Phone: (01772) 531343  
Email: peter.iles@lancashire.gov.uk  
Your ref: 3/2025/0489  
Our ref: 3\_2025\_0489-LCC2  
Date: 10<sup>th</sup> October 2025

**Application 3/2025/0489: Proposed extension to manufacturing facility with associated HV Substation, external plant compound and new/displaced car park.**

**BAE Systems, Samlesbury Aerodrome, Myerscough Smithy Road, Balderstone BB2 7LF**

Project:	7295								
Title:	Proposed Car park Site Plan (Planning) - Reduced								
Project no:	7295	Scale:	As indicated	Drawn by:	JL	Checked by:	KC	Date:	24/09/2025
Drawing no:	OSE-WMA-XX-DR-A-00-020	Status:	D2	Rev:	P02

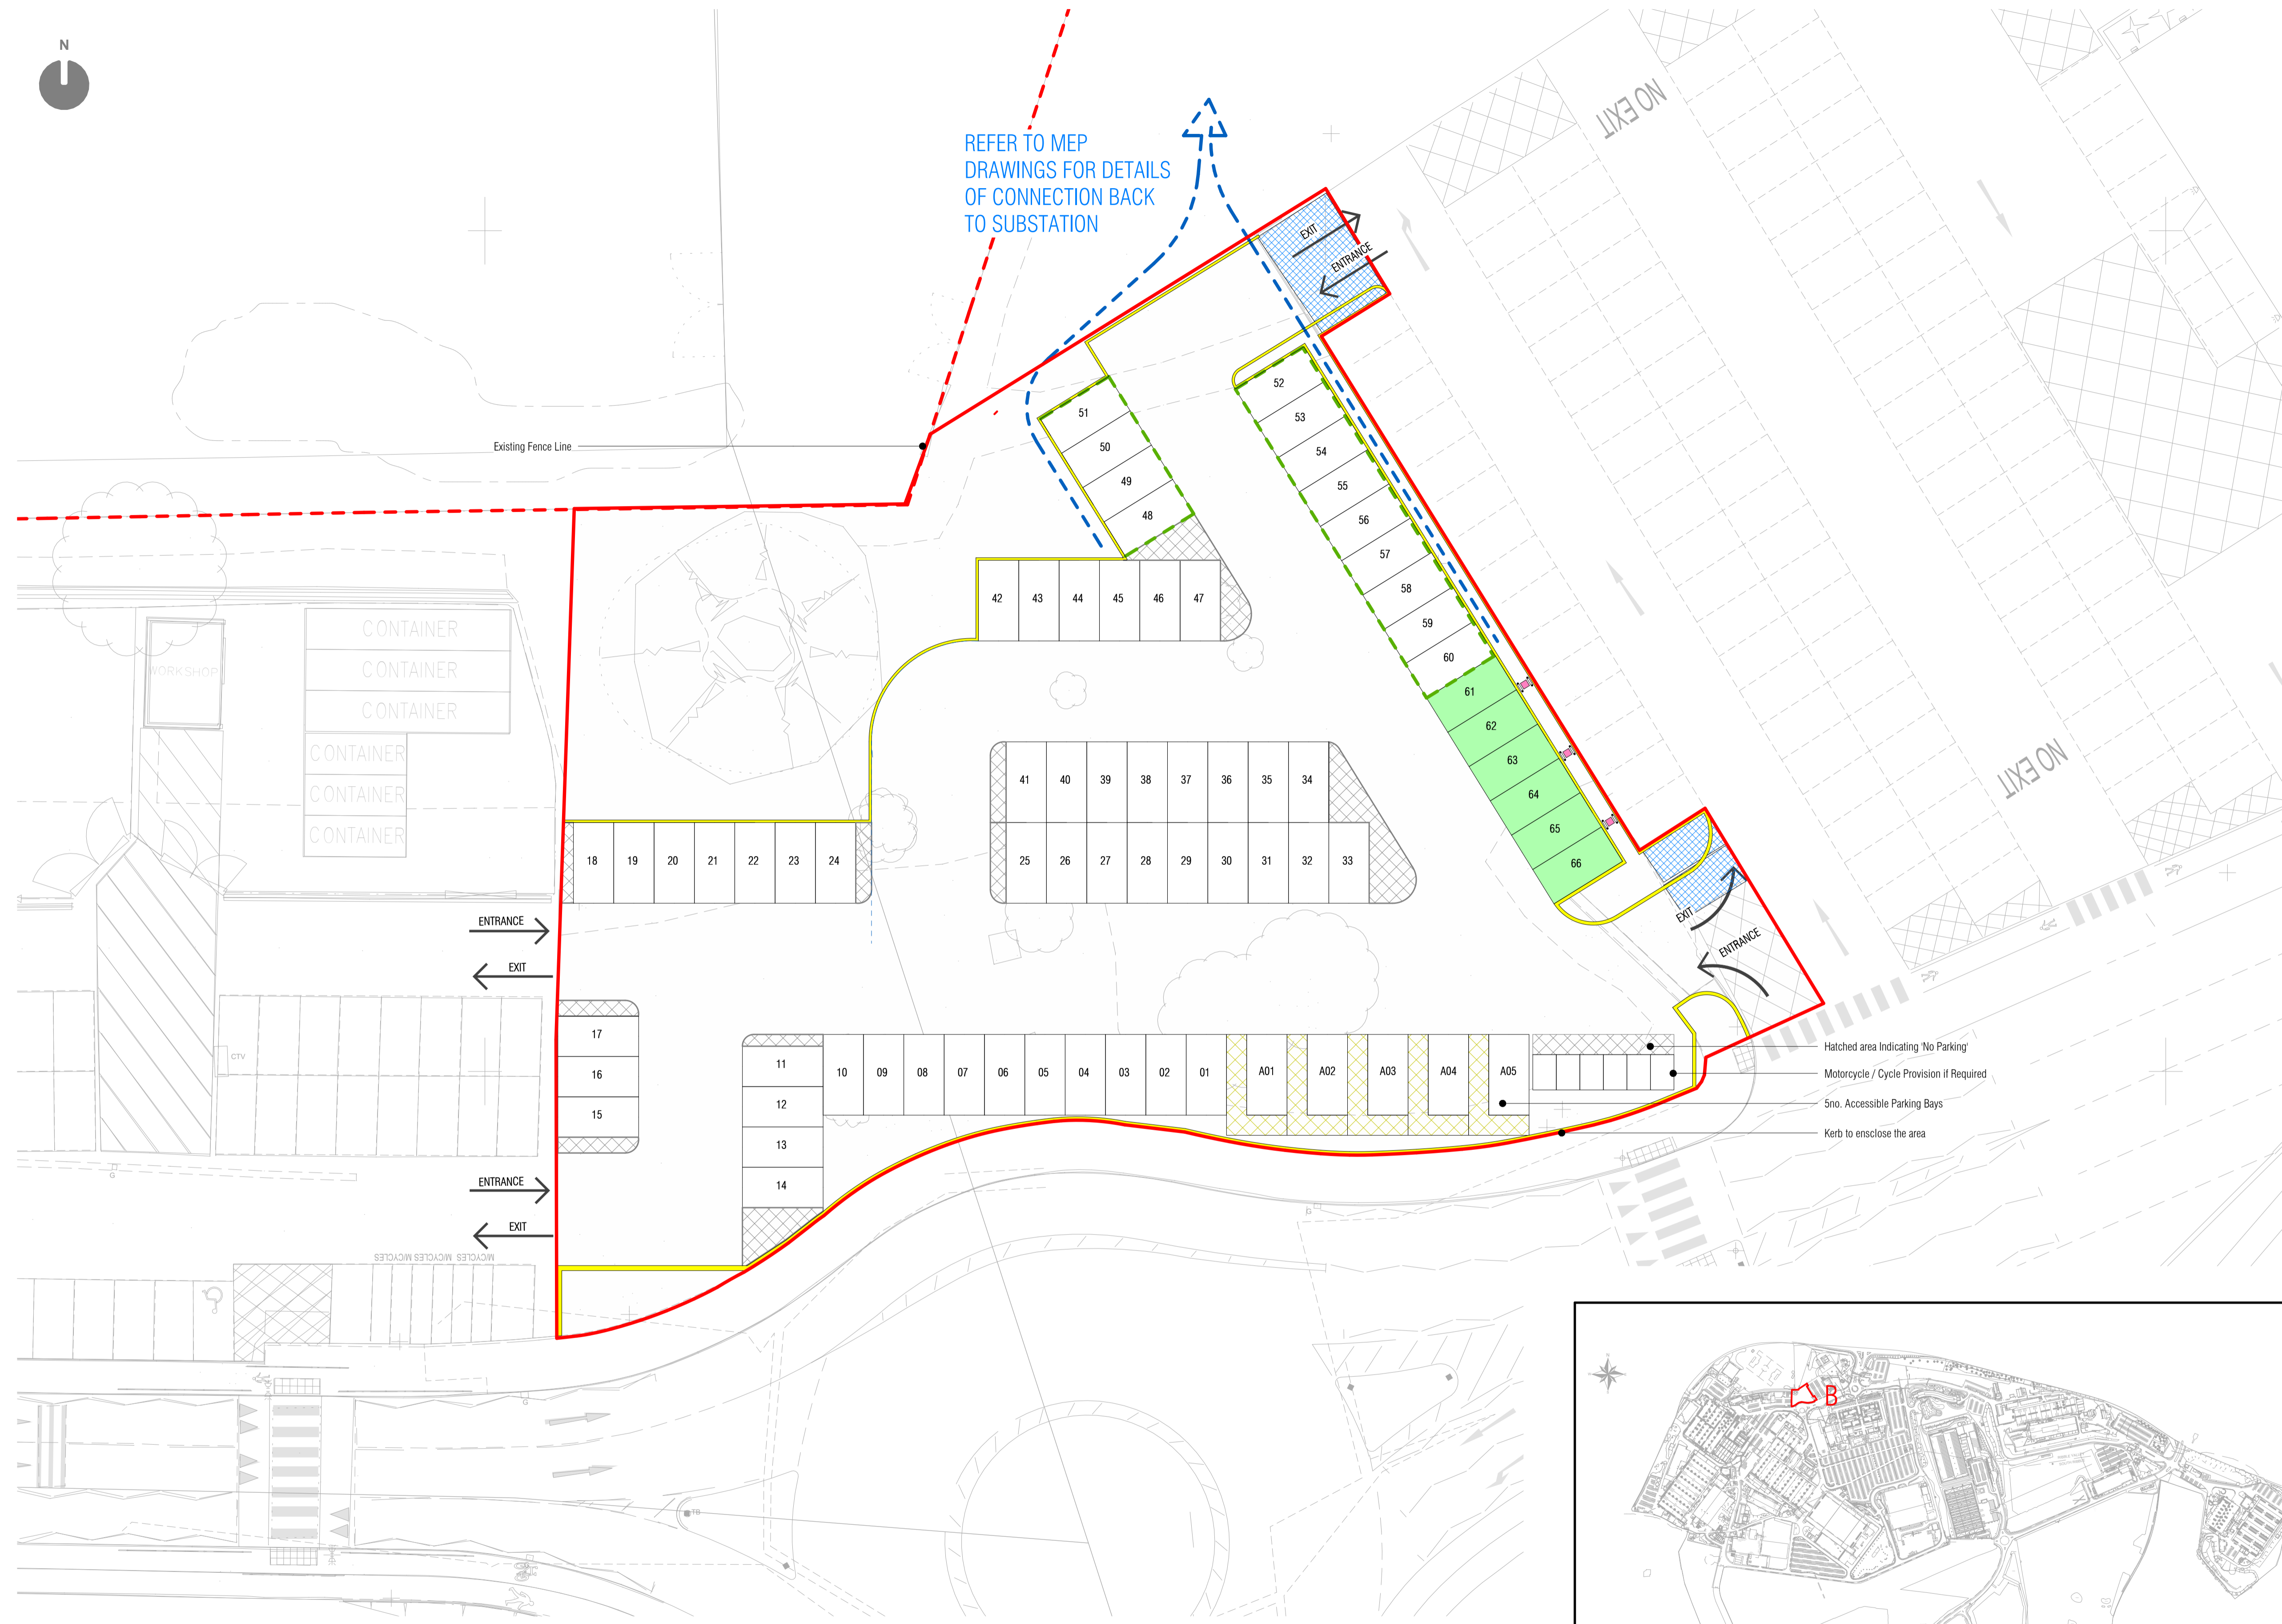
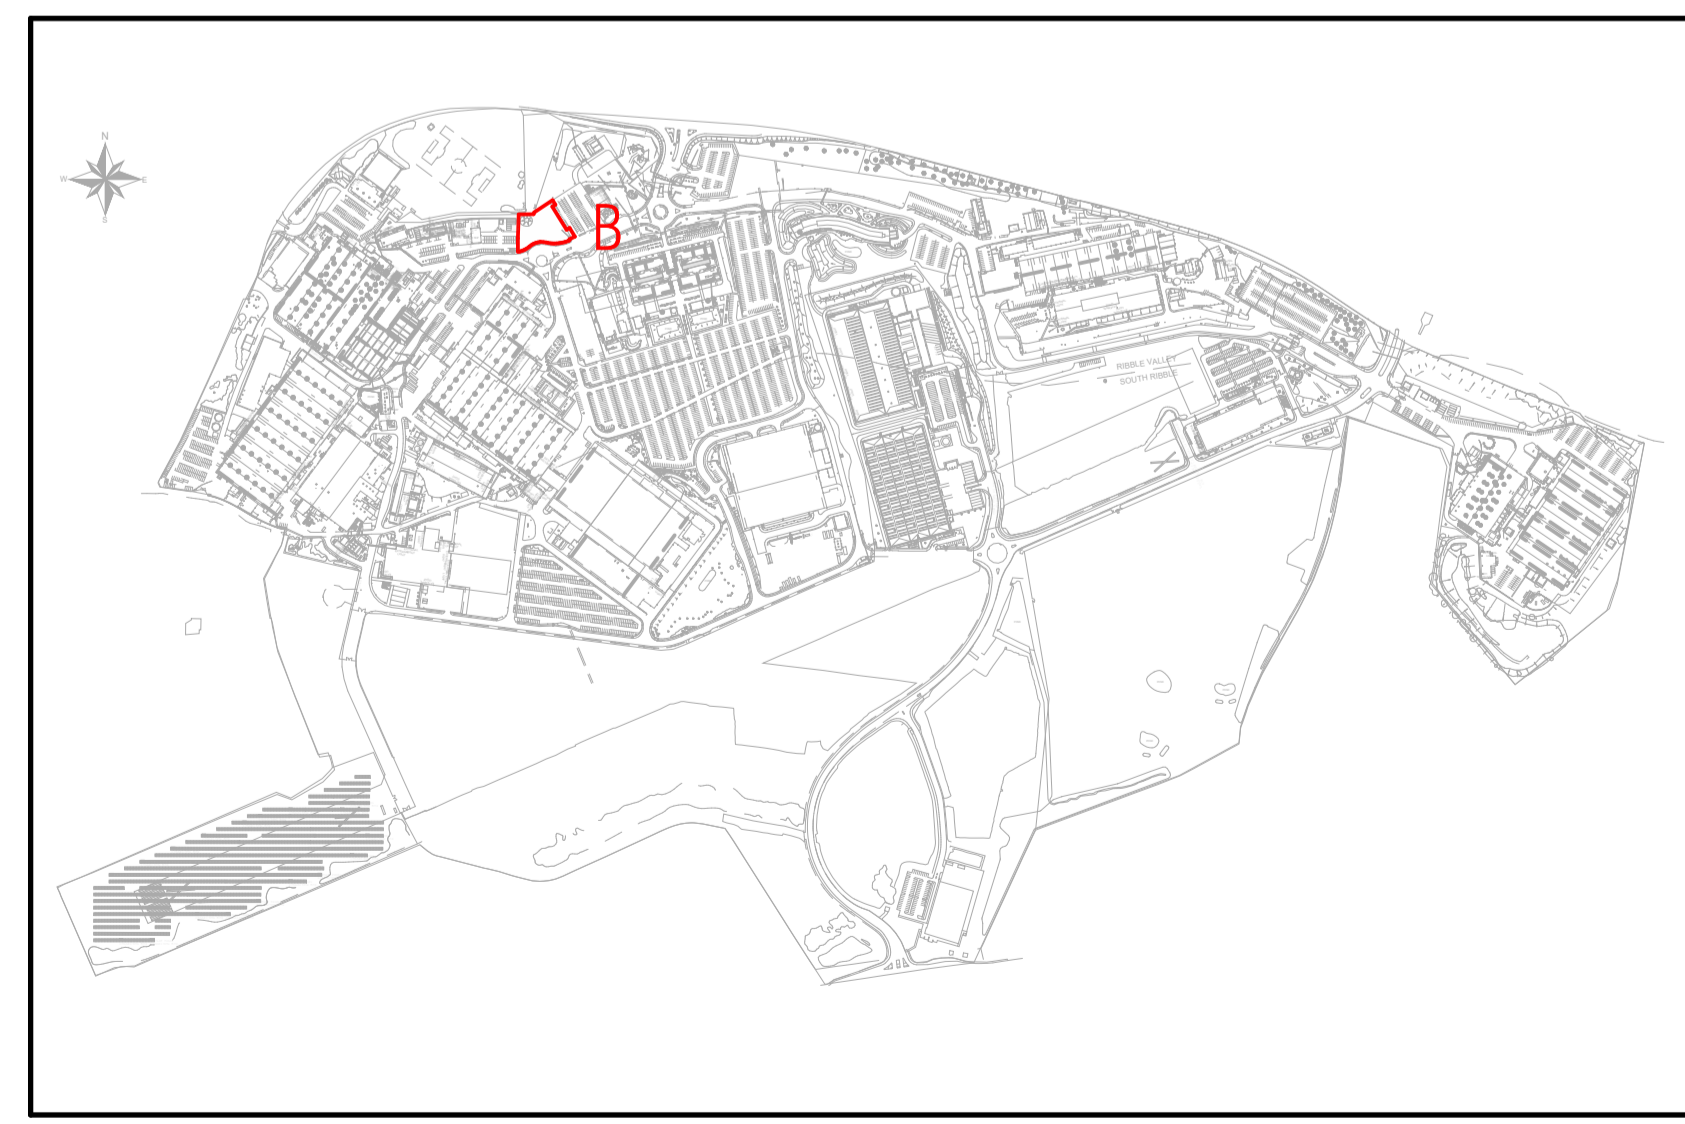
Thank you for your re-consultation on the above application and the two new documents. The comments made on the 26<sup>th</sup> of September relating to the newly uncovered concrete emplacement are still relevant, but as the structure is now back within the development red line, it would appear to be appropriate to place a condition on any consent granted relating to the recommended research, recording and presentation of the structure as part of the development. We would stress that great care needs to be taken when cleaning the structure out so that any surviving WWII fixtures and fittings, graffiti, wall art, etc. are not unnecessarily damaged or removed. It is probable that an archaeological contractor with experience of WWII structures could undertake these works, but other professionals and enthusiasts may have a role to play in the recording, research and interpretation of the site. Particular expertise may be found with specialists at Historic England (and their publications e.g. <https://historicengland.org.uk/images-books/publications/twentieth-century-military-sites/>), or with the Pillbox Study Group ([www.pillbox-study-group.org.uk](http://www.pillbox-study-group.org.uk)).

- (i) Recording:  
**Condition:** The recently revealed WWII concrete structure within the site boundary shall be carefully uncovered and retained in situ as part of the development. A Written Scheme of Investigation for the necessary excavation, emptying and careful cleaning shall be developed, along with a scheme of archaeological building recording to level 2-3 as set out in '*Understanding Historic Buildings*' (Historic England 2016) This Written Scheme shall be submitted by the applicant, or their agent or successors in title, and agreed in writing by the Local Planning Authority prior to the

**Condition:** A formal scheme of presentation of the remains of the recently uncovered WWII concrete structure within the site boundary shall be developed and agreed in writing with the Local Planning Authority prior to the facilities consented coming into use. That scheme shall be implemented according to a timetable agreed as part of the scheme. It shall include the provision of at least one permanent, accessible and free-standing information board located immediately adjacent to the structure setting out its date, functions and how it related to other contemporary structures and features for the defence of the airfield.
